From: Sarah Burrow <Sarah.Burrow@arun.gov.uk>
Sent: 14 June 2022 14:52
To: Planning.Responses <Planning.Responses@arun.gov.uk>
Cc: Maria Tomalova <Maria.Tomalova@arun.gov.uk>
Subject: RE: Planning Consultation on: BR/77/22/PL

Engineers Comments Regarding Surface Water Drainage

Application No: BR/77/22/PL
Registered: 25th April 2022
Site Address: Rear of 42 Sudley Road Bognor Regis PO21 1ES
Grid Reference: 493596 99284
Description of Works: 2 No. semi-detached 3-storey houses with parking and new vehicular access. This application is in CIL Zone 4 and is CIL liable as new dwellings.

PROPOSED GROUND FLOOR PLAN

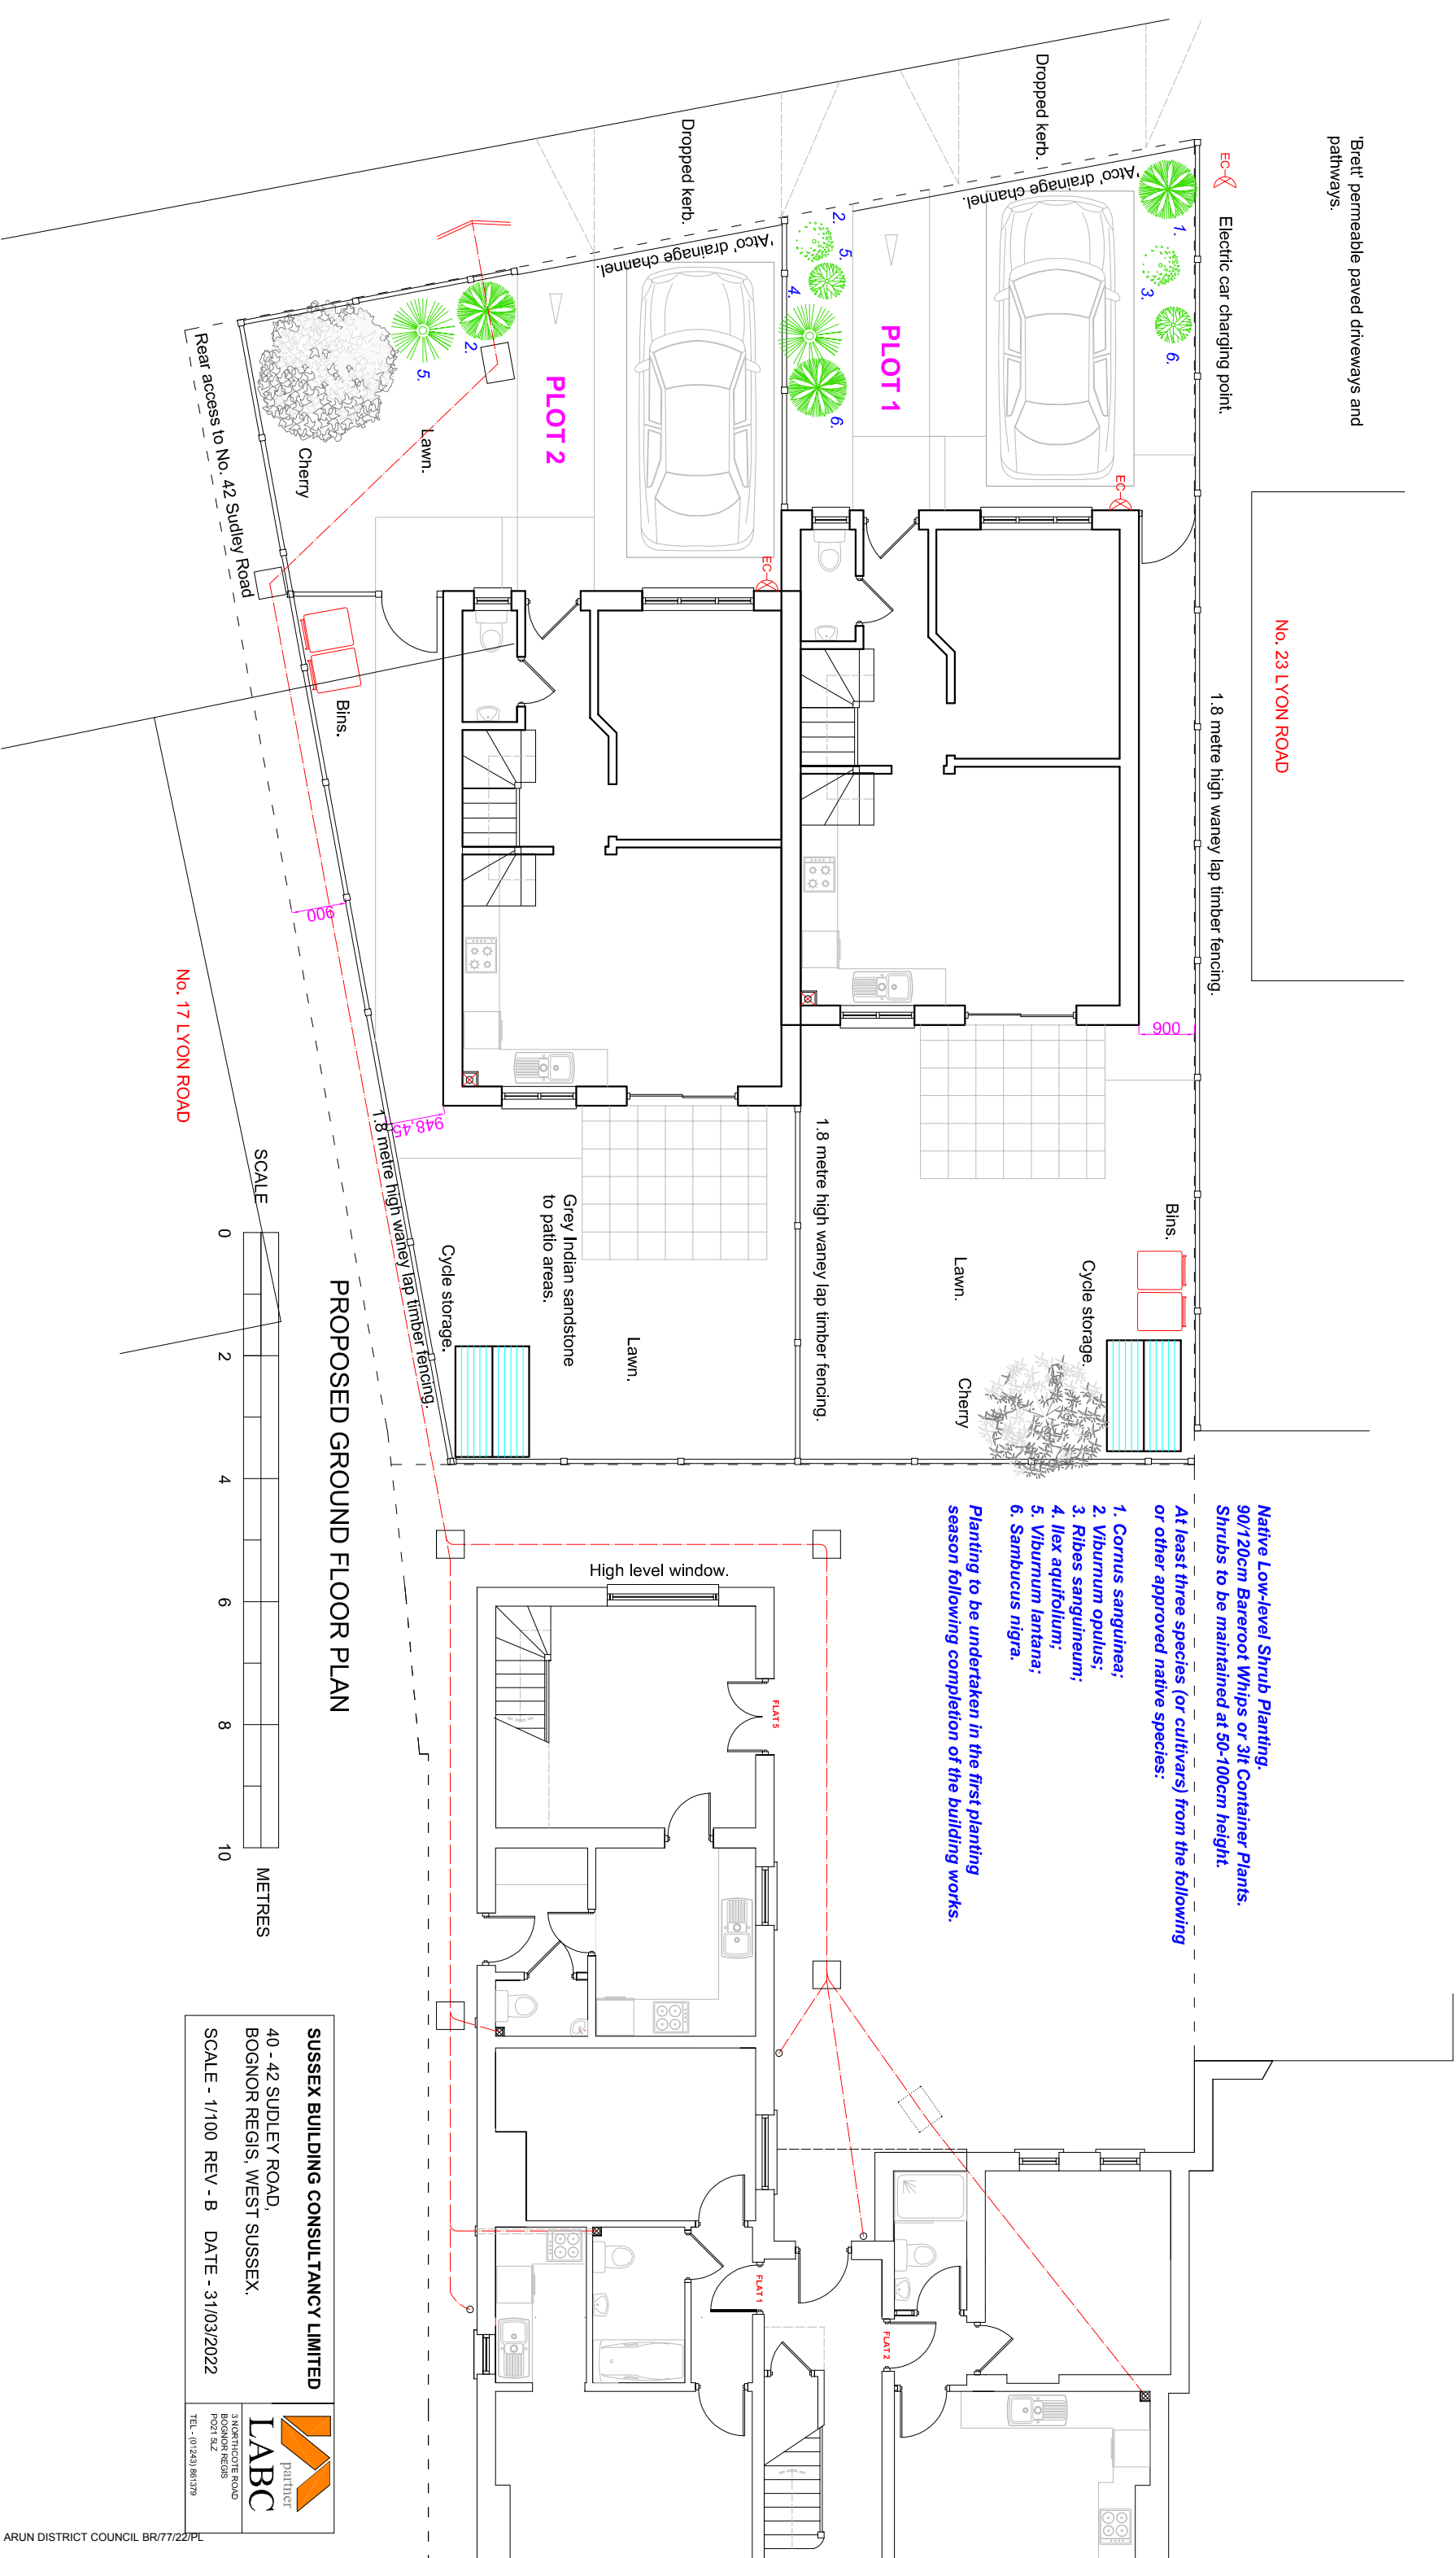
The proposed layout shows there is very limited space for surface water drainage, it appears that the proposals will not comply with West Sussex Lead Local Flood Authority Policy for the Management of Surface Water Policy 1. The supplied Drainage Statement even acknowledges that "There is no room to discharge the rainwater into soakaways on the site". This is an acknowledgement that the proposed layout and density of development precludes the use of infiltration, rather than the ground conditions on the site.

To overcome my objection the applicant should complete winter groundwater monitoring and winter infiltration testing and complete calculations to assess the size of structures required. A rough plan should be formed showing where these structures can be provided within the proposed layout. Evidence that no pumping or ground raising would be also be required. Detailed design of the system can be left until discharge of conditions where the applicant should provide the level of information stated within our checklist [Drainage Planning Consultations | Arun District Council](#)
